Application number: 2023/90464	
What is the application for?:	Erection of extensions to form two-storey dwelling
Address of the site or building:	126, Gomersal Lane, Gomersal, Cleckheaton, BD19 4JQ
Postcode:	BD19 4JQ

West Elevation
Scale 1:100

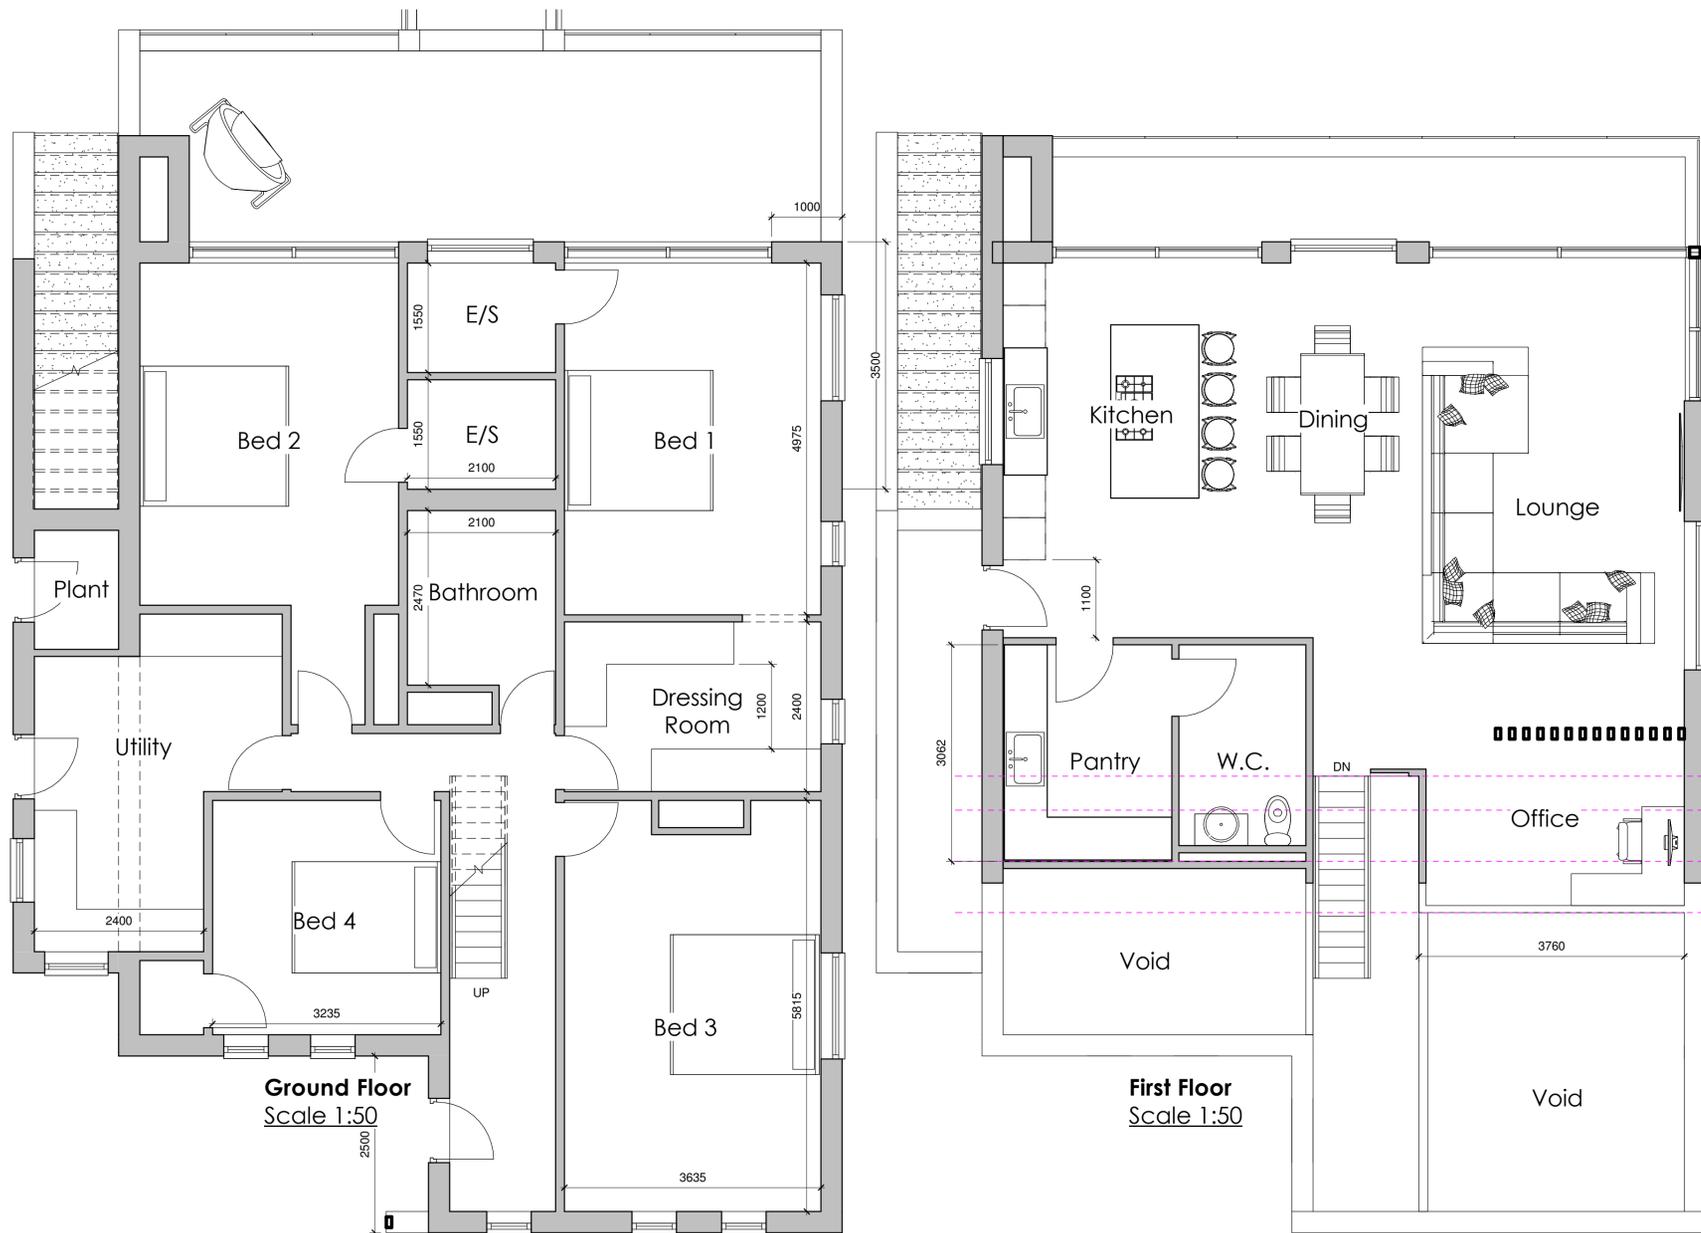
Type of comment: A general comment	
Do you wish your comments to be published on the website anonymously?	Yes
<p>There are concerns regarding the existing proposed plans for the West elevation and in particular the design, number and placement of the windows. As the building is in the vicinity of a listed building and adjacent to the Local Authority Conservation Area the current design of the West elevation is not considered to be in keeping with other buildings in the locality, and there is a problem with overlooking neighbouring buildings creating lack of privacy issues.</p> <p>These concerns have been raised directly with the applicant and a draft alternative design has been created, although I understand that these amendments have not as yet been submitted to the Kirklees Planning department for consideration. Therefore the concerns outlined above relate to the original proposed plans.</p>
